**Blue Gum Community School (SSD-10444)
Response to Submissions**

ATTACHMENT 1

DRAWING TITLE
B99 VEHICLE TURNING PATHS
 Entering Site

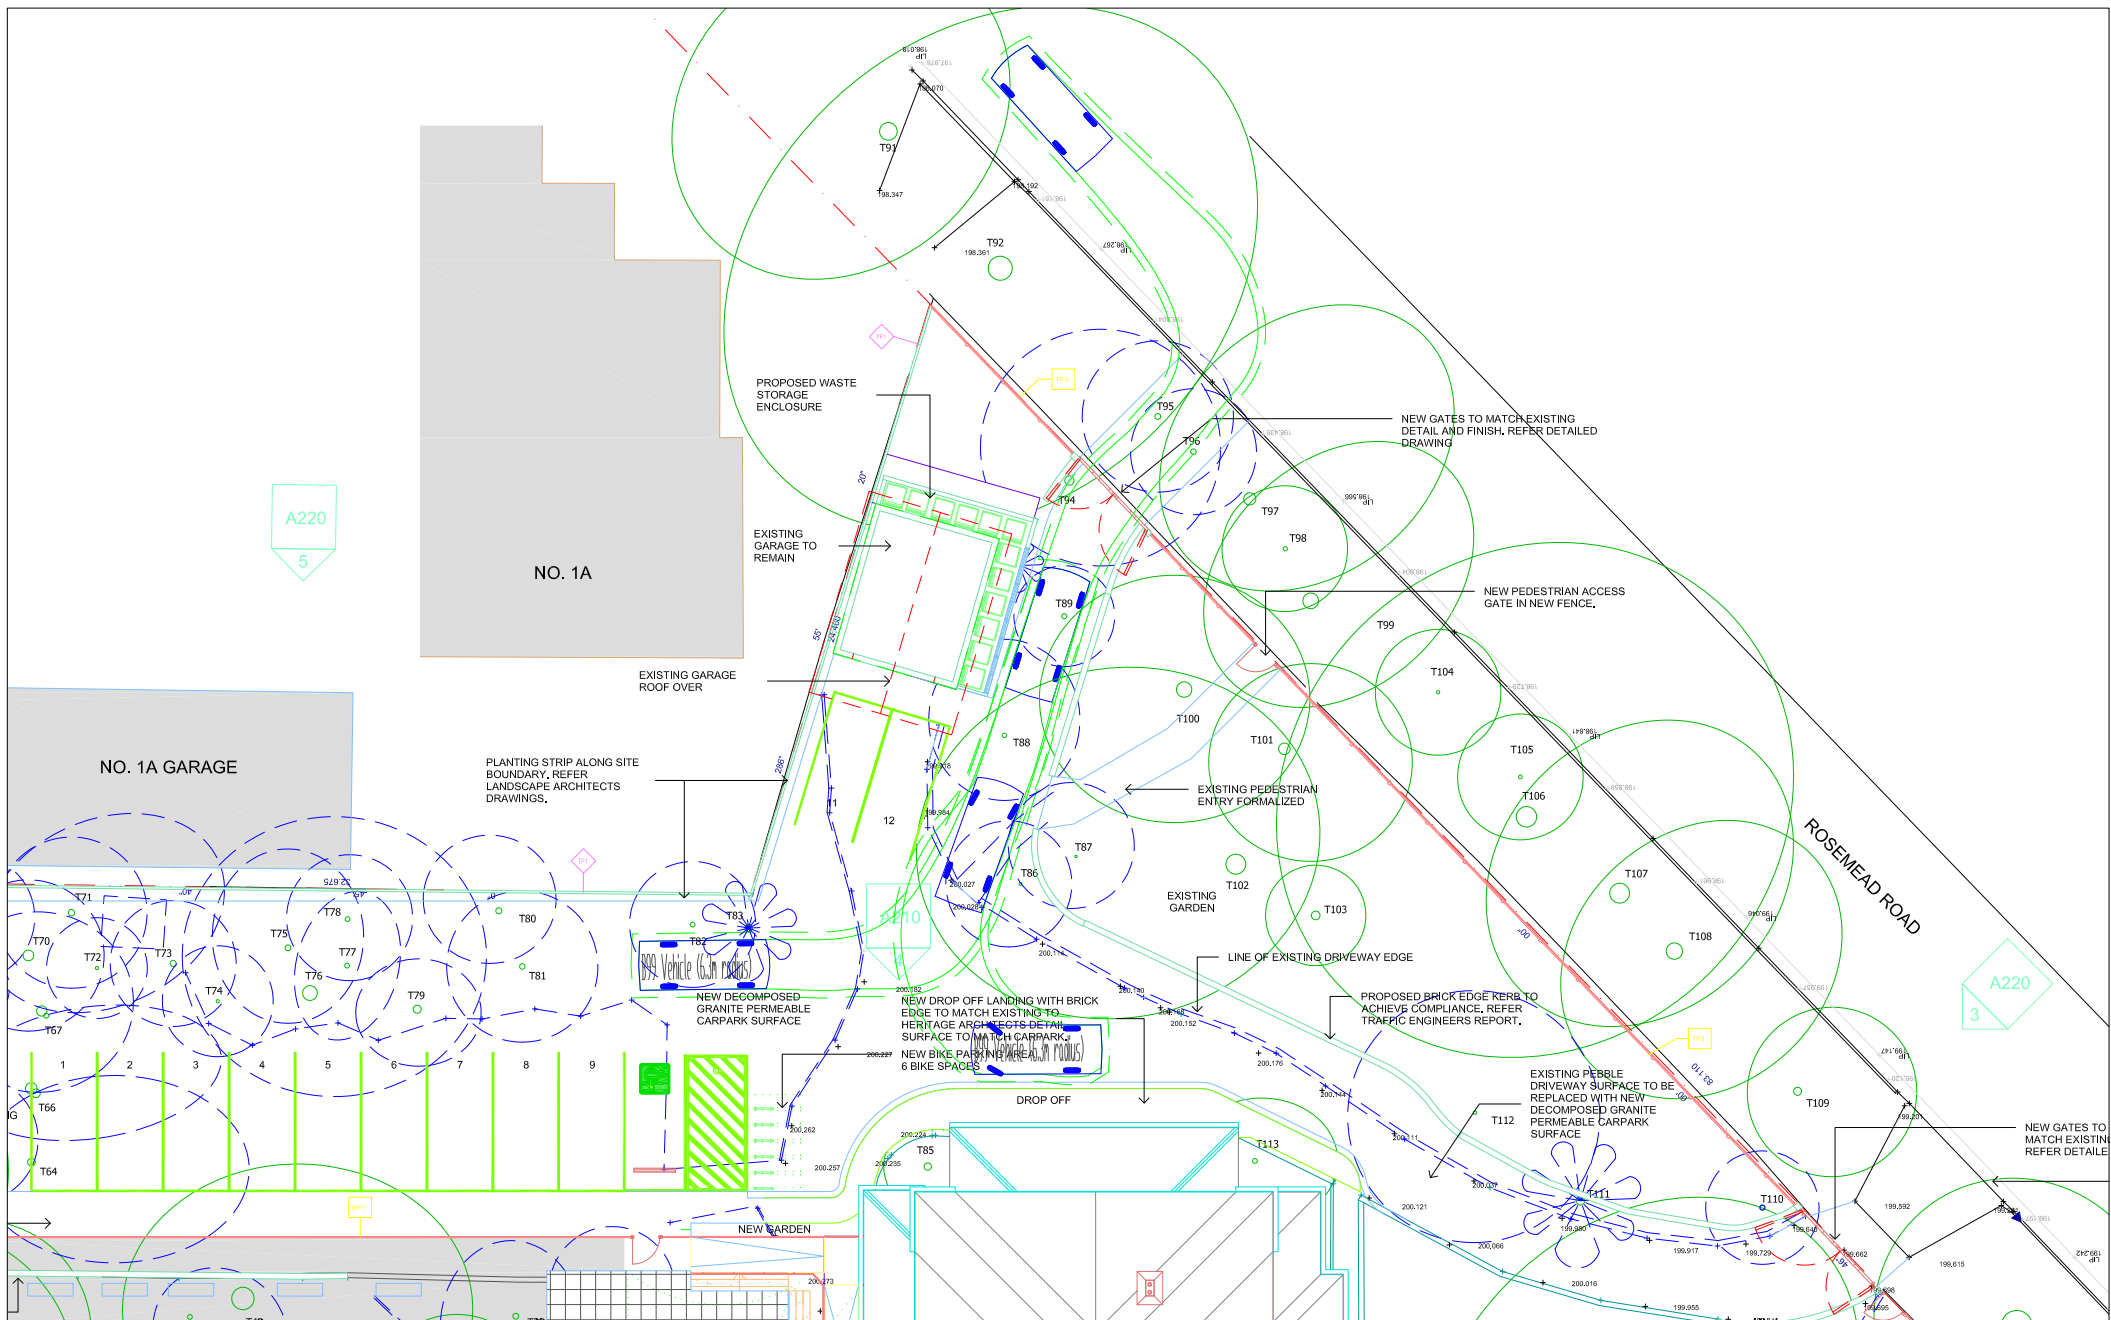
- The TIA indicates that the entry driveway from Rosemead Road has sufficient space to accommodate six cars, which are expected to queue within the site during the morning and afternoon peak drop-off / pick-up times. In this regard, please provide a layout to indicate how the six cars would be accommodated within this area without impacting on the traffic flow on Rosemead Road (due to vehicle queuing outside the site boundary).

Title
SITE AND ROOF PLAN

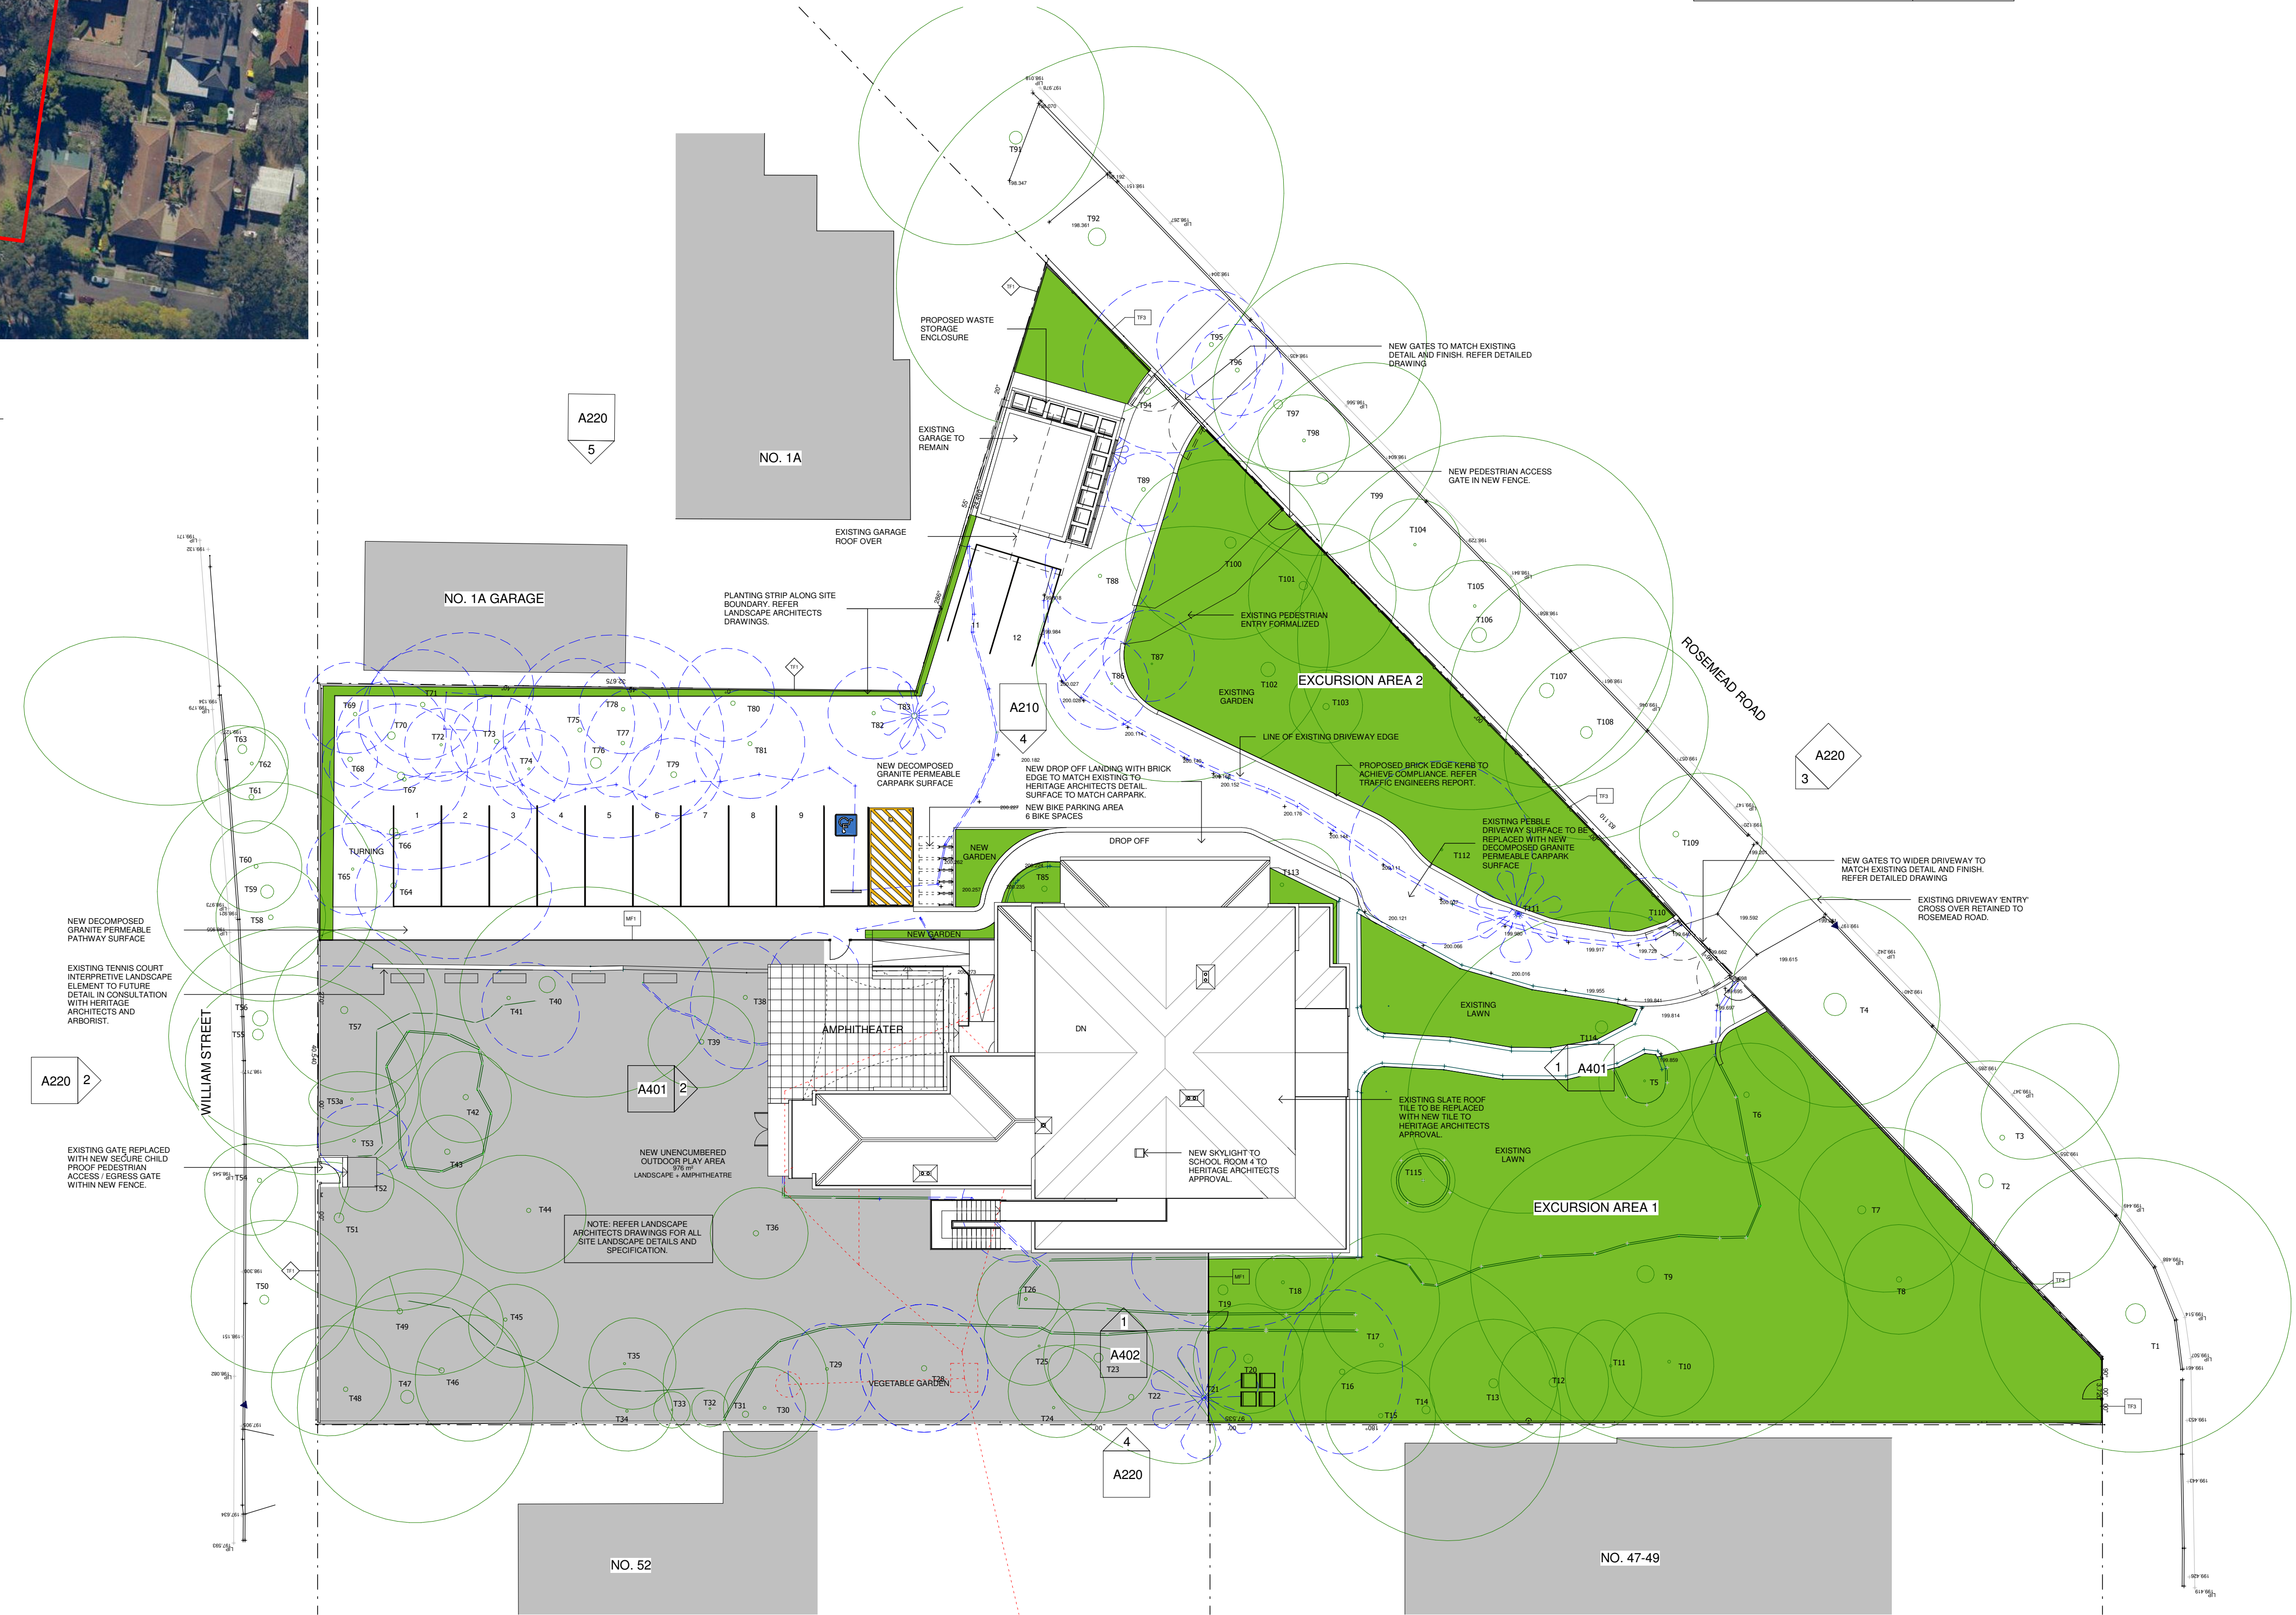
- The EIS and the Traffic Impact Assessment Report (TIA) suggest that the 'No Parking' restriction can be removed to allow for drop-off / pick-up to occur on Rosemead Road in front of the site. The Department considers that this would not be a desirable outcome as it would remove parking spaces currently used by the residents on the street, during certain times of the day. The Department recommends that the entire drop-off / pick-up operation should be undertaken within the site.

- Considering the comments from Hornsby Shire Council (Council) in relation to the impacts on the heritage values of the site that it considers would result from the proposed driveway works and the additional vehicular crossover, the Department recommends that an alternative driveway design option with a single entry / exit point be investigated. Sufficient reasons should be provided to justify whether this design option is feasible for the site. Consideration should be given to relevant Australian Standards in considering access options.

- The Department raises concerns regarding the removal of a number of trees that are currently located at the boundary of the site and the adjoining property at 1A Rosemead Road, Hornsby (western boundary). The trees along the boundary currently screen the two developments, contribute to the overall tree canopy for the site and also complement the heritage values of the site.

- The Department recommends that the design for the carpark should be amended to retain as many trees as possible along this boundary fence.
- The Department is concerned that further tree removal / pruning of tree canopy or clearing of understorey vegetation would be needed to comply with the requirements of an Asset Protection Zone within the site. In this regard, additional information would be needed to identify the trees that may need removal and how the tree canopy of the site can be maximised while complying with the requirements of Planning for Bushfire Protection.
